WOODFORD MFG.

WOODFORD - ADDITION
2121 WAYNOKA ROAD
COLORADO SPRINGS, CO 80915
EL PASO COUNTY, COLORADO

1 SITE PLAN

Markup Summary

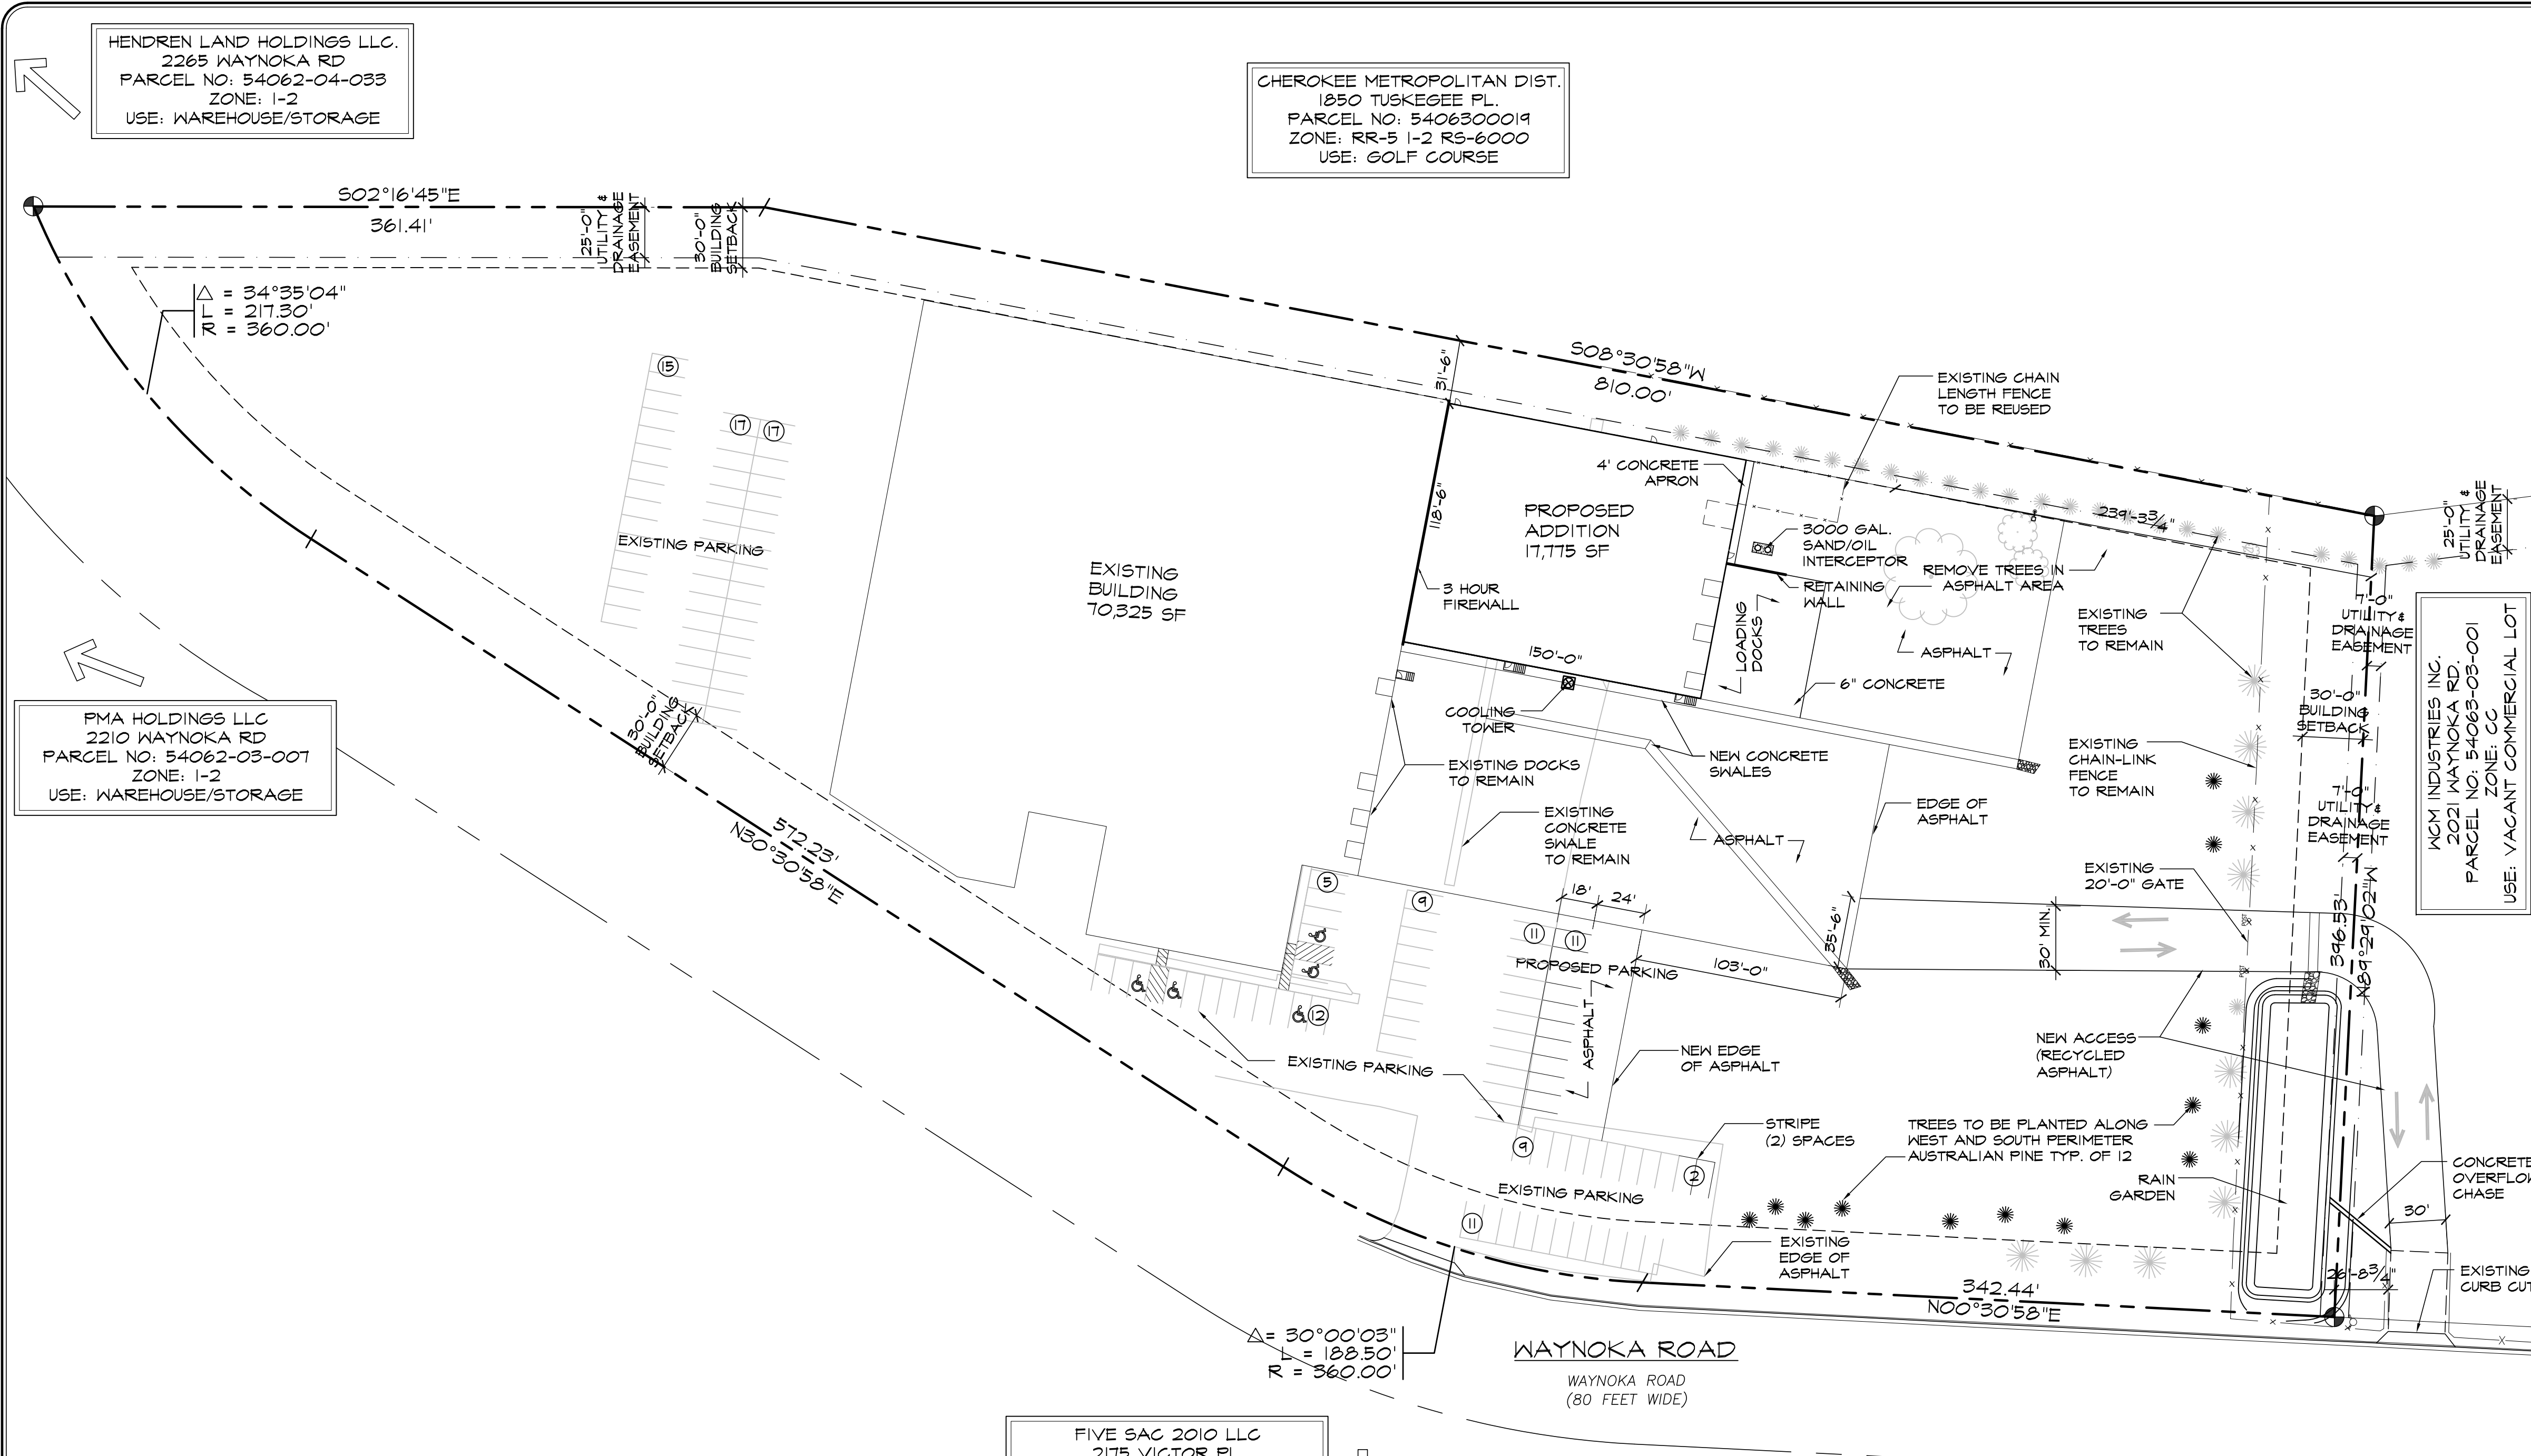
A driveway access permit is required.

Add "PCD File No. PPR1837"

101-150 parking spaces requires 5 ADA parking spaces.

Include ADA note and Route.

Show water line easement detailed in Title Commitment.
